**Consultation Response from KC,
Highways Development Management**

2024/93366 former Britvic premises, Willow Lane, Birkby, Huddersfield, HD1 5EB

Change of use from B2 to mixed used site consisting of B2 (General Industry), B8 (Storage and distribution), class E (offices), Class F (Learning and non-residential institutions), exhibition / venue space.

Responding Ref: 5-8NW-25.

SECOND FLOOR

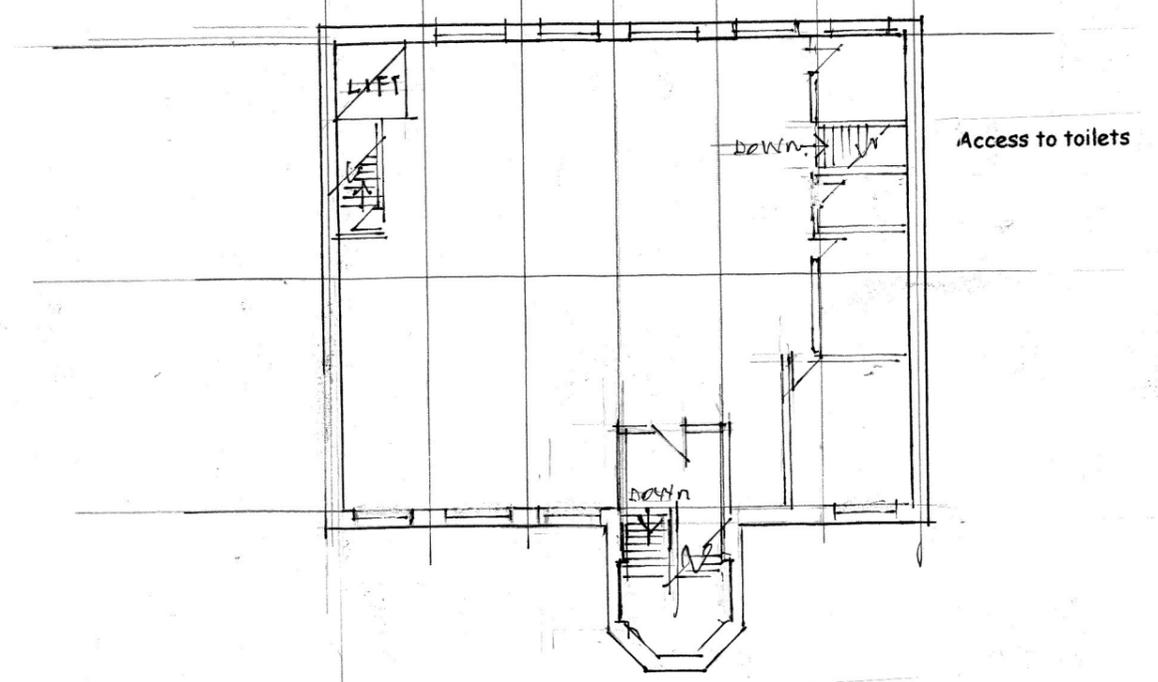
The second floor is to be for community use. Venue hire, Workshops and training classes, home of connection hub.

An existing service yard is to become a car park with 28 spaces. How will the existing warehousing that is to be retained be serviced with the loss of the service yard.
